**Consultation Response from KC,
Highways Development Management****2024/92092 527, Bradford Road, Fixby, Huddersfield, HD2 2LH****Excavation works to form vehicular access and parking space****Date Responded: 23/10/2024****Responding Officer: D. Stainsby****Responding Ref: K4-15NW/7**

This application is for excavation works to form vehicular access and parking space at 527 Bradford Road, Fixby, Huddersfield.

Proposed driveway area

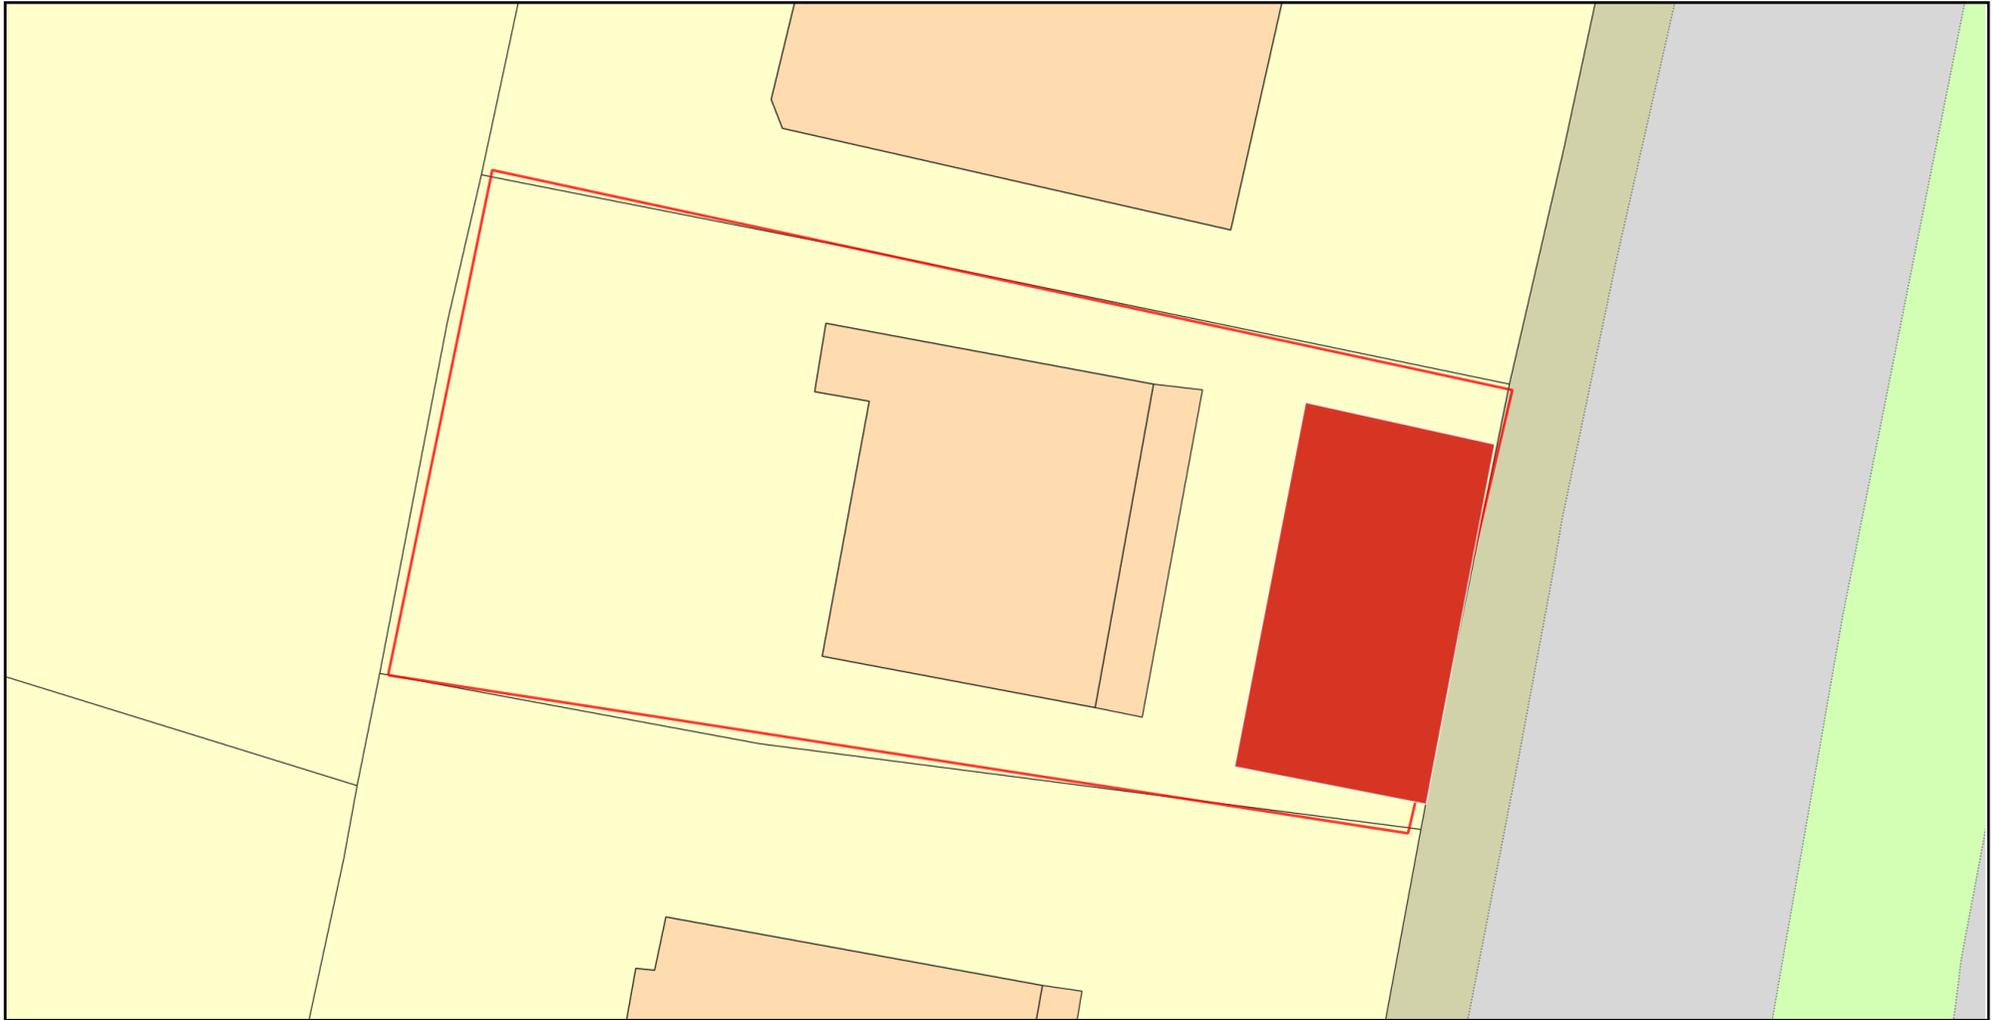
Currently the dwelling does not have any off-street parking, and the proposal includes for the provision of one off-street parking space which will remove parking from the highway.

The proposed off street parking space will negate the need to park on the highway at this location and there should be no additional highway safety concerns based around this.

proposed plan

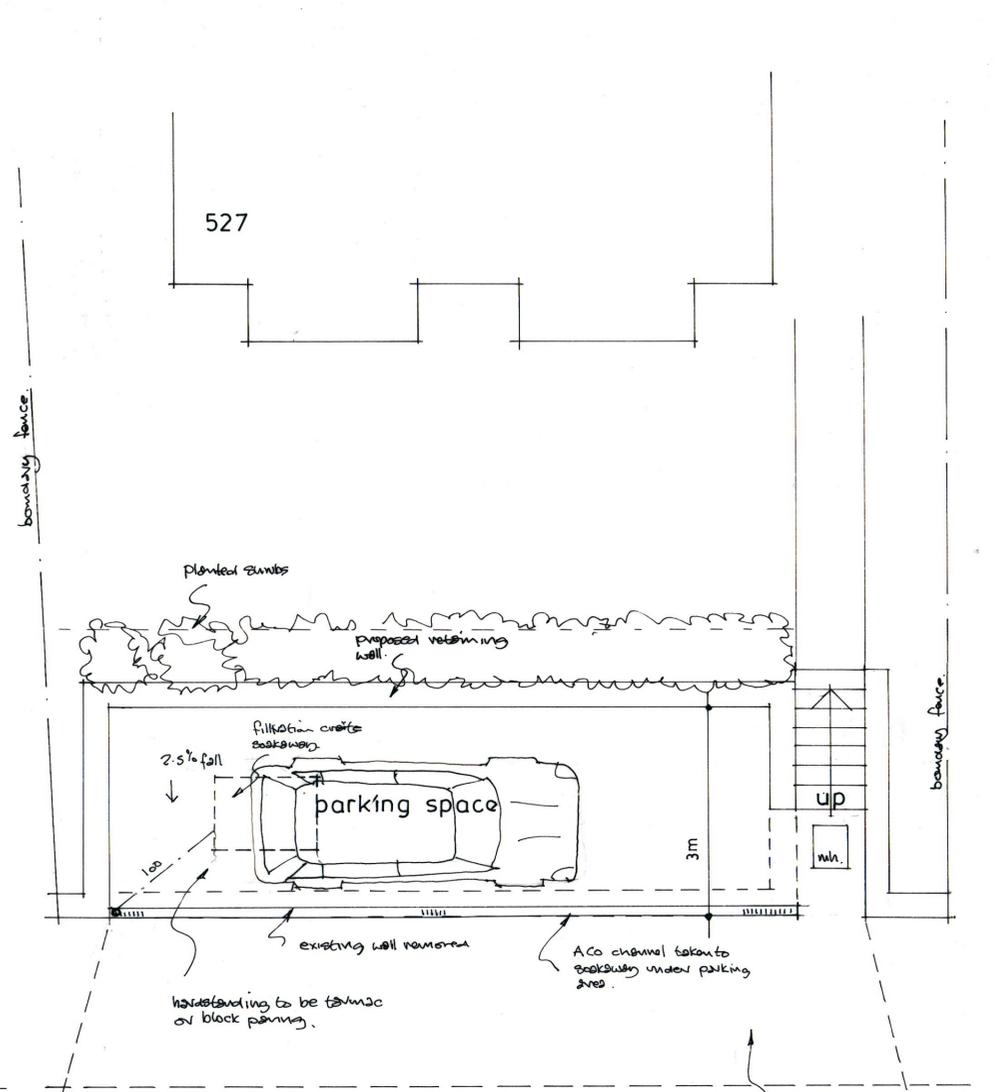
The proposed parking space is parallel to the highway and will allow for the vehicle to drive onto and off the parking space in forward gear.

The approved vehicle parking areas will need to be surfaced and drained in accordance with the Communities and Local Government; and Environment Agencies 'Guidance on the permeable surfacing of front gardens (**parking areas**)' published 13th May 2009 (ISBN 9781409804864) as amended or superseded.

A new vehicular crossing will need to be provided for the proposed driveway to the existing dwelling.

The changes to the access within the adopted highway fronting the property, to provide a dropped kerb, will need to be constructed under a section 184 agreement of the 1980 Highways Act (vehicle crossings over footways and verges). You are required to consult the Design Engineer (Kirklees Street Scene: 01484 221000) with regard to obtaining this permission and approval of the construction specification. Interference with the highway without such permission is an offence which could lead to prosecution.
